# CITY OF ALBUQUERQUE

April 19, 2016

**Re: Eclectic Restaurant Renovation**  
**2119 Menaul Blvd. NE**  
Traffic Circulation Layout  
**Architect's Stamp Date: 4/8/2016; H16D002**

AS-103

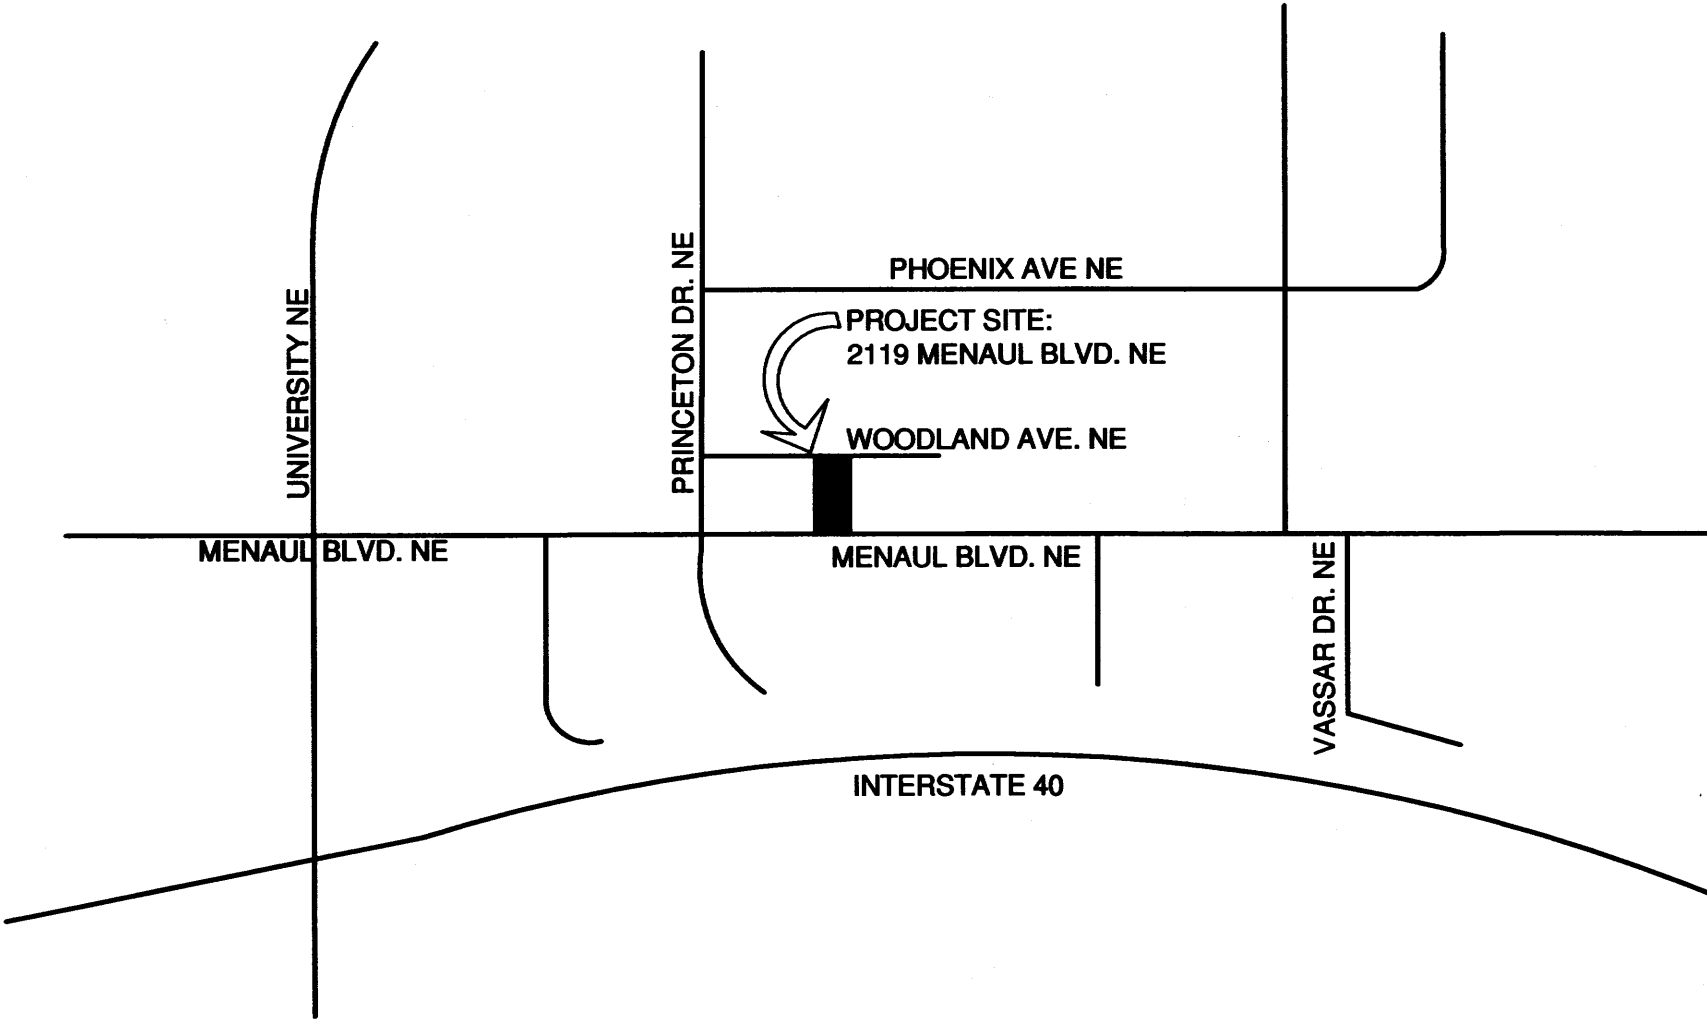
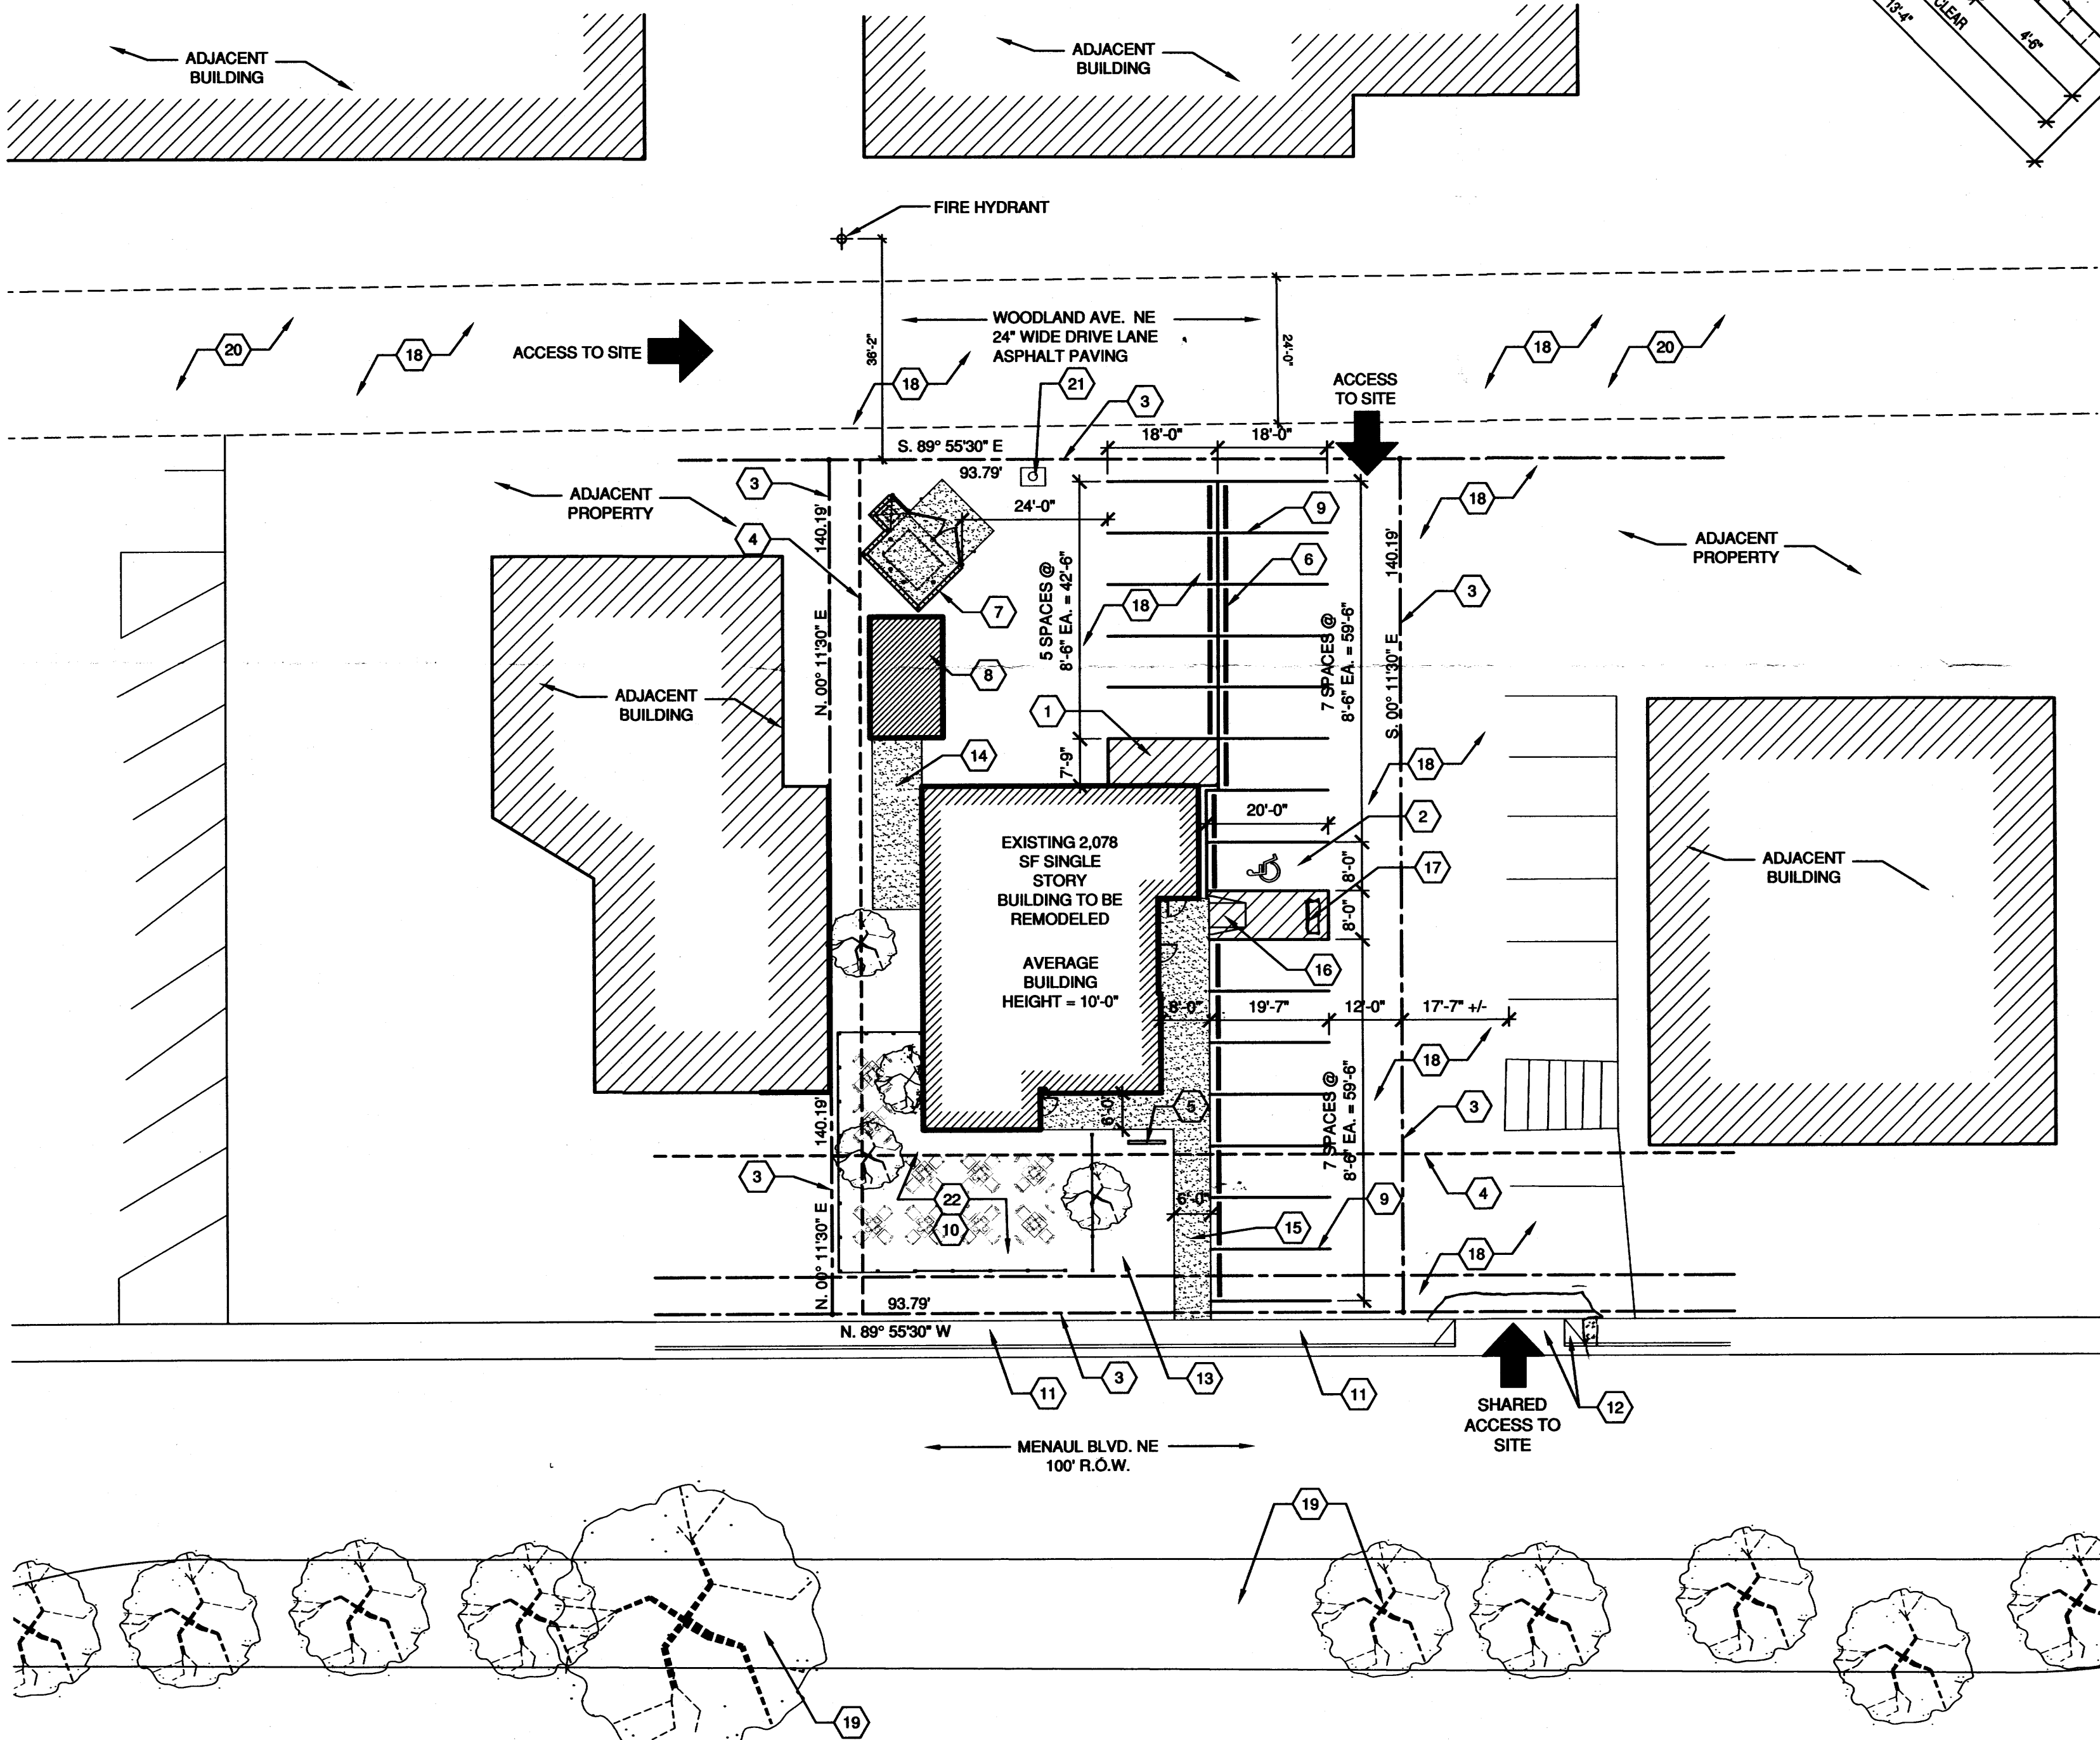
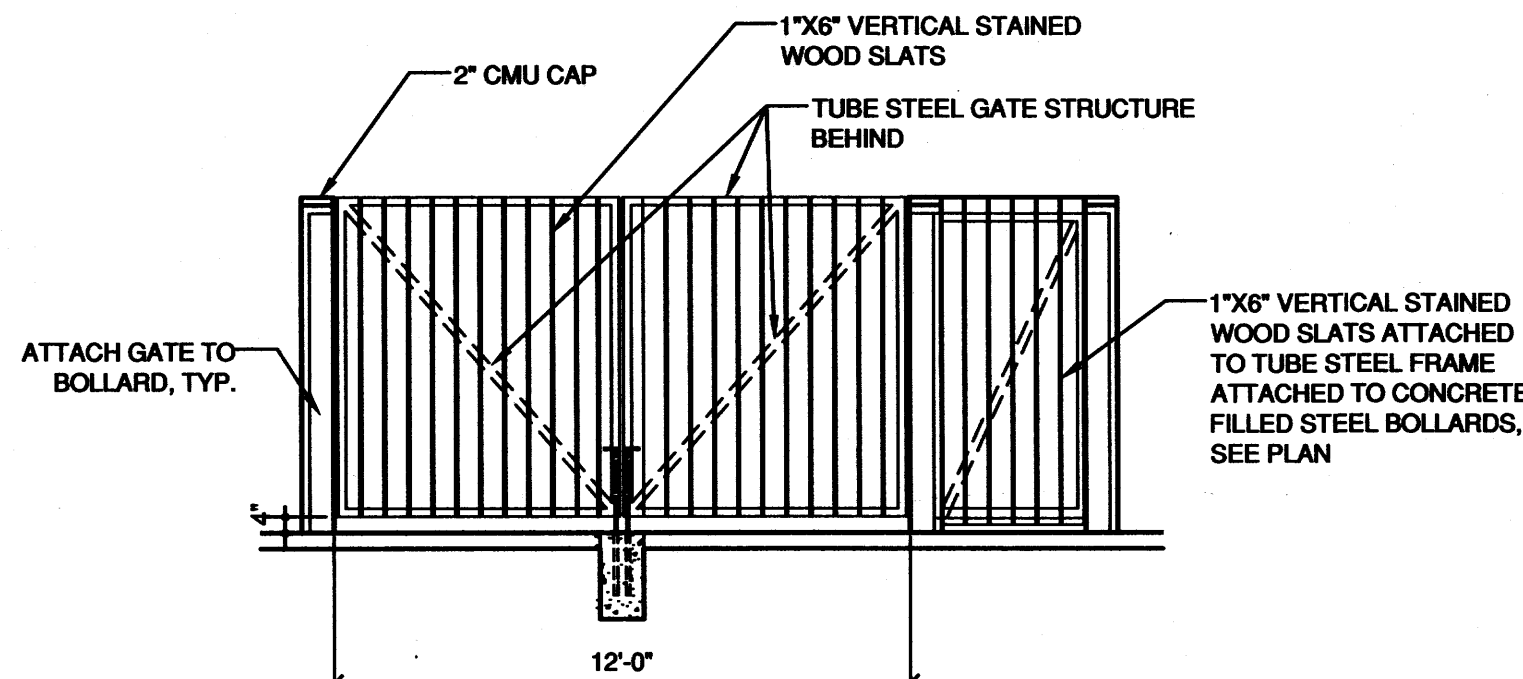
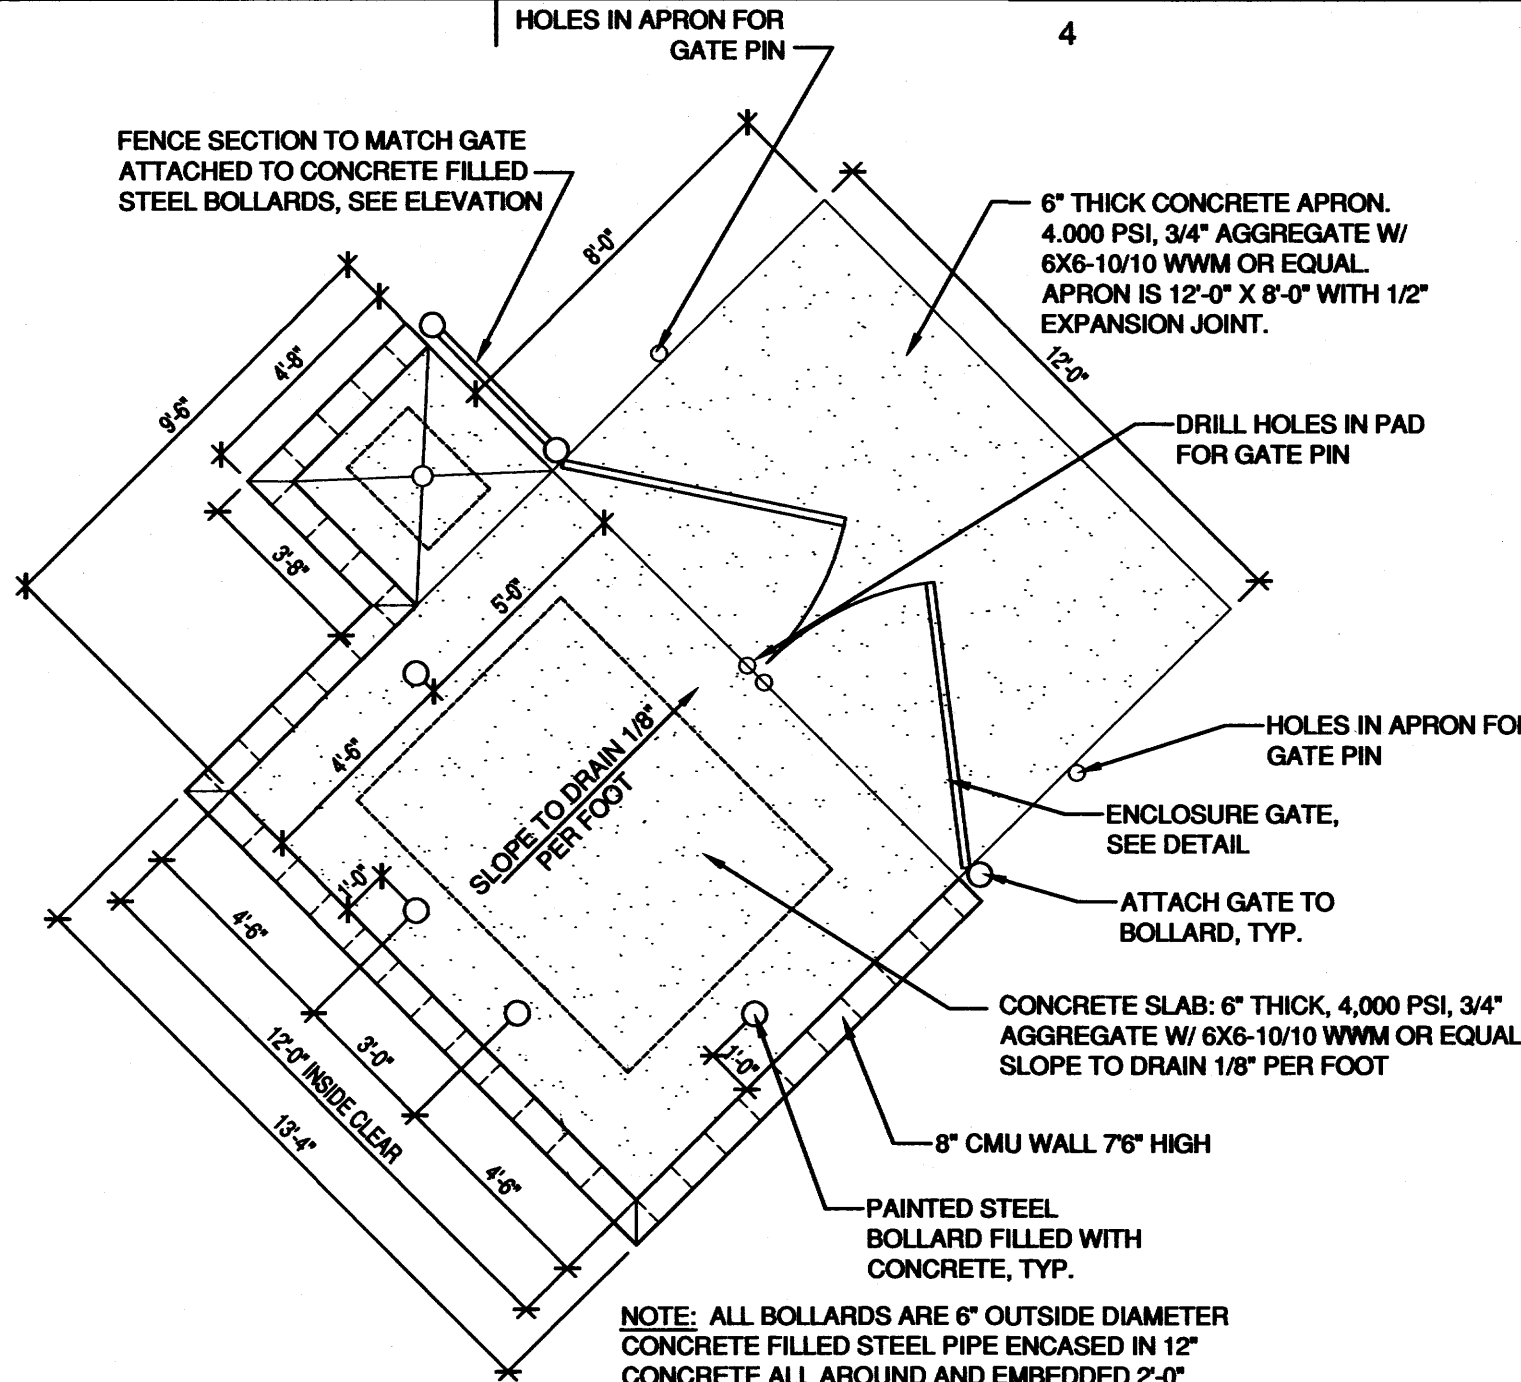
1. Please review and revise plan to provide all information listed on the attached Traffic Circulation Layout Check List.
2. Identify all existing access easements and right of way width dimensions.

3. Identify the width of the curb cut adjacent to Menaul Blvd.
4. The ADA accessible parking sign must have the required language per 66-7-352.4C NMSA 1978 **"Violators Are Subject to a Fine and/or Towing."** Please call out detail and location of HC signs.

5. The ADA access aisles shall have the words **"NO PARKING"** in capital letters, each of which shall be at least one foot high and at least two inches wide, placed at the rear of the parking space so as to be close to where an adjacent vehicle's rear tire would be placed. (66-1-4.1.B NMSA 1978)

6. Per DPM, a 6 ft. wide ADA accessible pedestrian pathway is required from the public sidewalk to the building entrances. Please clearly show this pathway and provide details.

7. Per DPM, a 6 ft. wide ADA accessible pedestrian pathway is required from the HC parking stall access aisles to the building entrances. Please clearly show this pathway and provide details.

8. Design delivery vehicle route needs to be shown.
9. Service vehicle and/or refuse vehicle maneuvering must be contained on-site; provide a copy of refuse approval.

10. Please specify the City Standard Drawing Number when applicable, for example, new sidewalk, new accessible ramp (Keyed Note 16), etc.
11. Is the accessible ramp (Keyed note 16) proposed or existing? If existing, does it meet ADA design standards?

12. Please include a copy of your shared access agreement with the adjacent property owner.
13. Please add a note on the plan stating "All improvements located in the Right of Way must be included on the work order."
14. All broken or cracked sidewalk must be replaced with sidewalk and curb & gutter. A build note must be provided referring to the appropriate City Standard drawing.
15. Please include two copies of the traffic circulation layout at the next submittal.
